**WEST SUSSEX COUNTY COUNCIL
INFRASTRUCTURE CONSULTATION**

DATE: 24/10/2008

SUBJECT: PA/25/08/ - Stationing residential mobile home for setteld gypsy accomodation, erection of 1.8m high gates & formation of crossover.

The Wood Yard, France Lane, Patching, West Sussex

Gates and Crossover

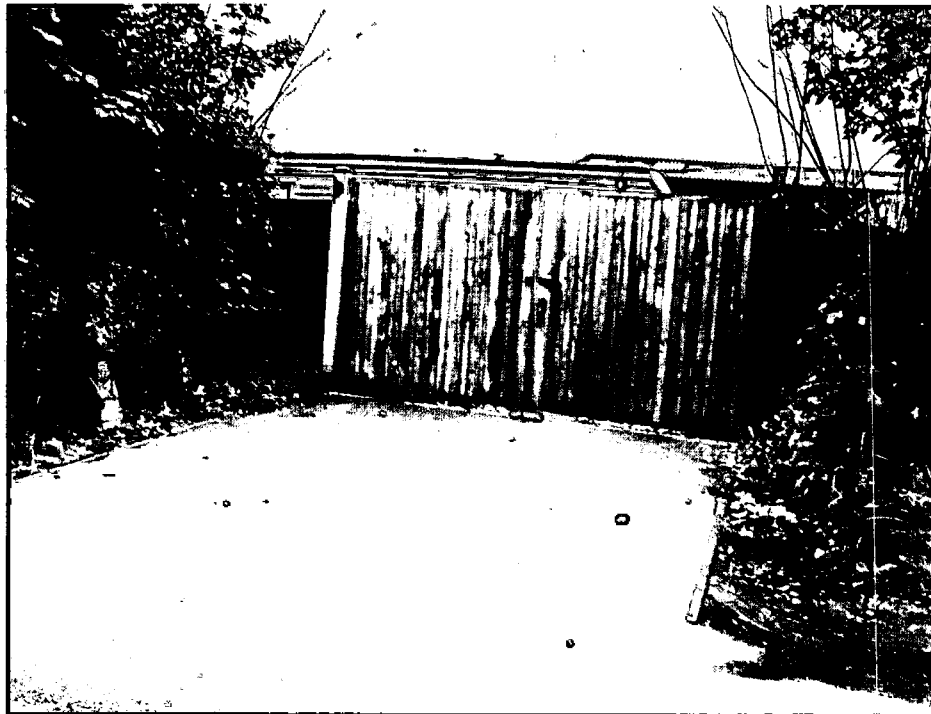
The proposal is for a residential mobile home with access onto France Lane via a new access point. From an inspection of the plans alone, there is no apparent visibility issue at the point of access onto France Lane. It is noted that the applicant is proposing gates at the new site vehicular access, these gates must open inwards of the property and be set back a minimum of 5 metres from the highway. The most recently available verified accident records reveal there have been no personal injury accidents in the vicinity of the proposed new point of access, indicating a low risk of highway safety issues with this proposal.

Any gates provided at the new site vehicular access shall open away from the highway and be set back a minimum of 5 metres from the nearside carriageway edge of the adjoining highway.

Reason – To ensure that vehicles can be driven off the highway before the gates are opened, in the interests of road safety.
